Please upload as rep letter for AW/337/19/A

OBJECTION TO : AW/337/19/A . One Stop Store Application for signage on the Ship Inn site

PROPOSED SITE SIGNAGE

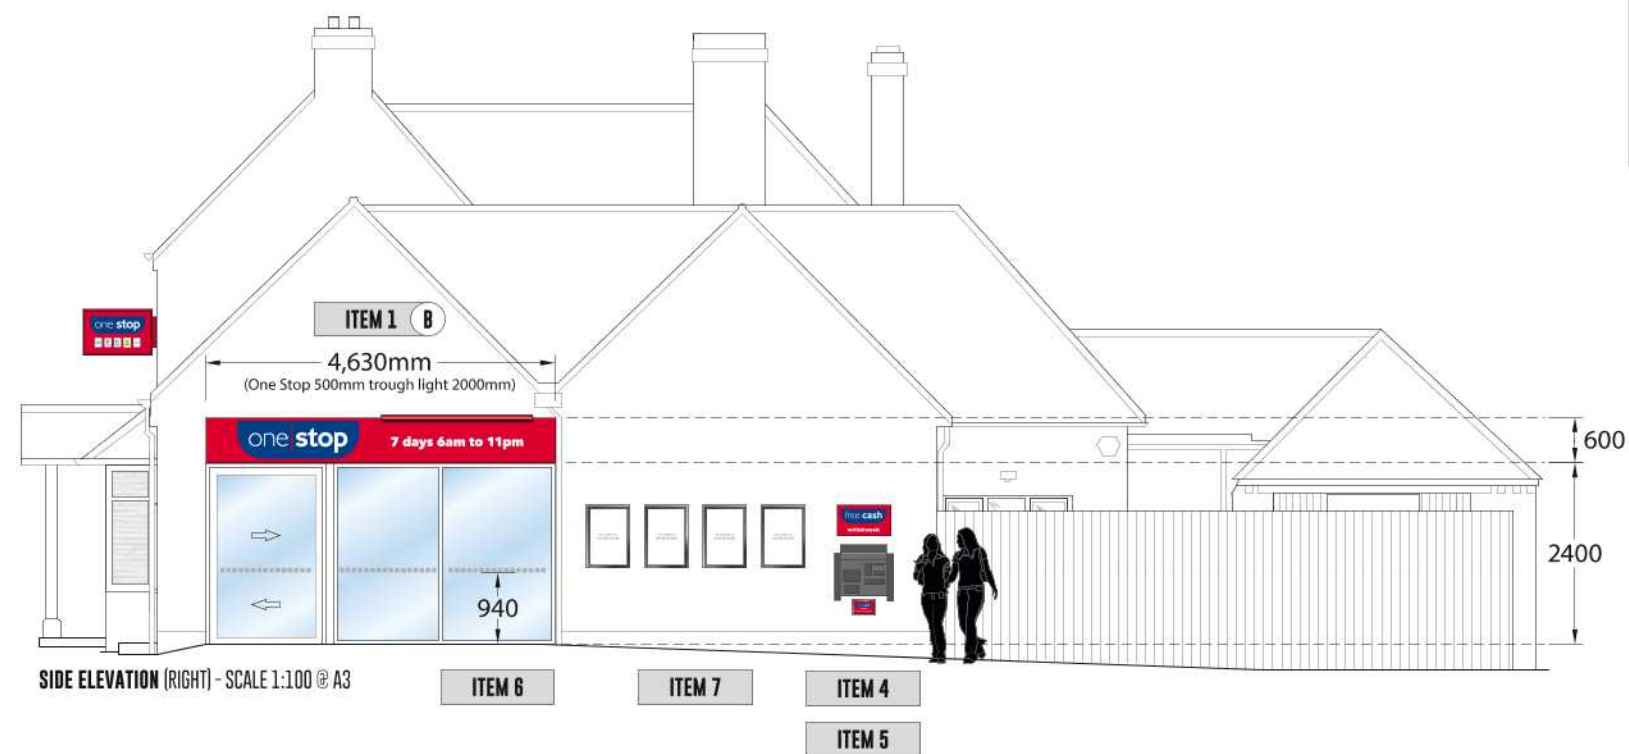
That aside, this further planning application seeks to erect inappropriate signage on the Ship Inn pub building and site, designated with Arun DC as an Asset of Community Value. The building is also recognised as of "special character" but the signage and its garish livery will degrade the building. It is out of keeping with the surroundings and the accompanying lighting will pollute the environment in the hours of darkness. With early recording of A ship Inn in Aldwick as long ago as 1811, it is quite astonishing that building of such significant character should be developed in this way.

PROPOSED SITE SIGNAGE

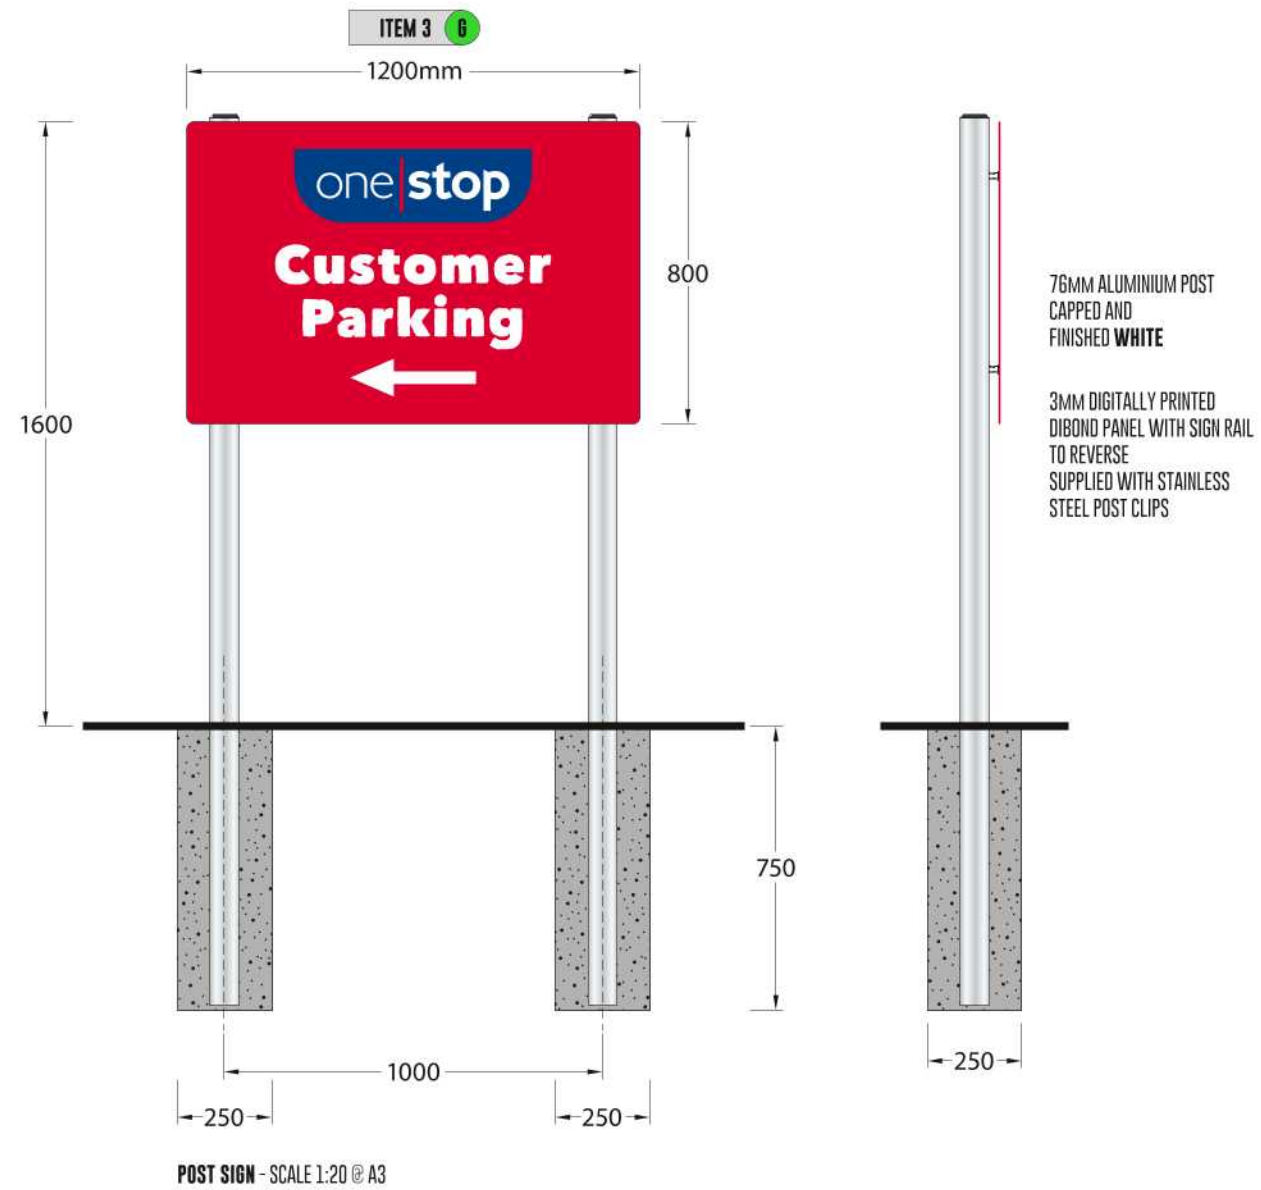
The proposed panels covering the bay windows disfigure the building and are out of character with the parade of shops on the other side of the road. The proposed sign in the car park entrance is an invitation to motorists to pull in quickly into the car park. Aldwick Street is busy and narrow, served by a blind bend from the East, so traffic is likely to be a safety hazard; especially during the time when an oversize delivery vehicle is on station.
